APPENDIX L ADDENDUM REFLECTIVITY ASSESSMENT

Powerhouse Parramatta SSDA Reflectivity Response to Submissions

This letter is in response to submissions raised as part of the public exhibition of the Powerhouse Parramatta State Significant Development Application relevant to the Reflectivity Report, PHM-ARP-REP-FA-0003 (Arup, April 2020).

Figure 1: Map of ferry's travel path showing turning circle where east facades cast solar reflections above 500 Cd/m²

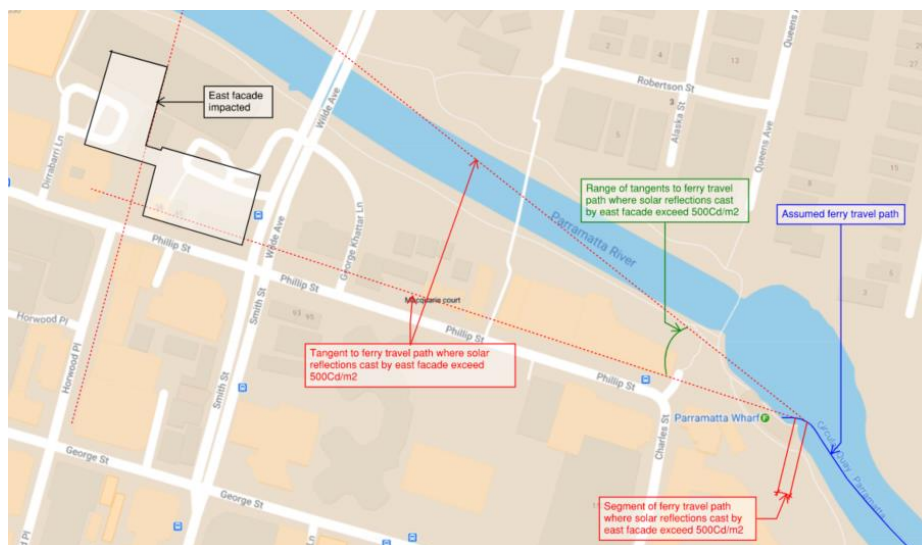
Provide further analysis and mitigation options for any reflectivity impacts on ferry operations.

The ferry approach on Paramatta River (Figure 1) has been reviewed for reflectivity impacts on ferry operators using the analysis method as for road traffic. Due to the limited exposure, the Reflectivity Report PHM-ARP-REP-FA-0003 noted that reflections are not expected to result in unacceptable glare towards ferry operators in this location. The below records additional considerations of mitigating factors and extent of reflection exposure to provide further context.

Viewed from the river, the east facades can potentially briefly cast solar reflections above the 500 Cd/m² threshold towards ferry operators (Figure 1). This only occurs at the ferry's turning circle, i.e. when the ferry turns to dock at the wharf (Figure 2). For the ferry travel path assumed, this is an approximately 8m stretch of the ferry's travel path (Figure 1). For the majority of the ferry's travel parallel to the river, the reflectance is below the 500 Cd/m² threshold (Figure 3).
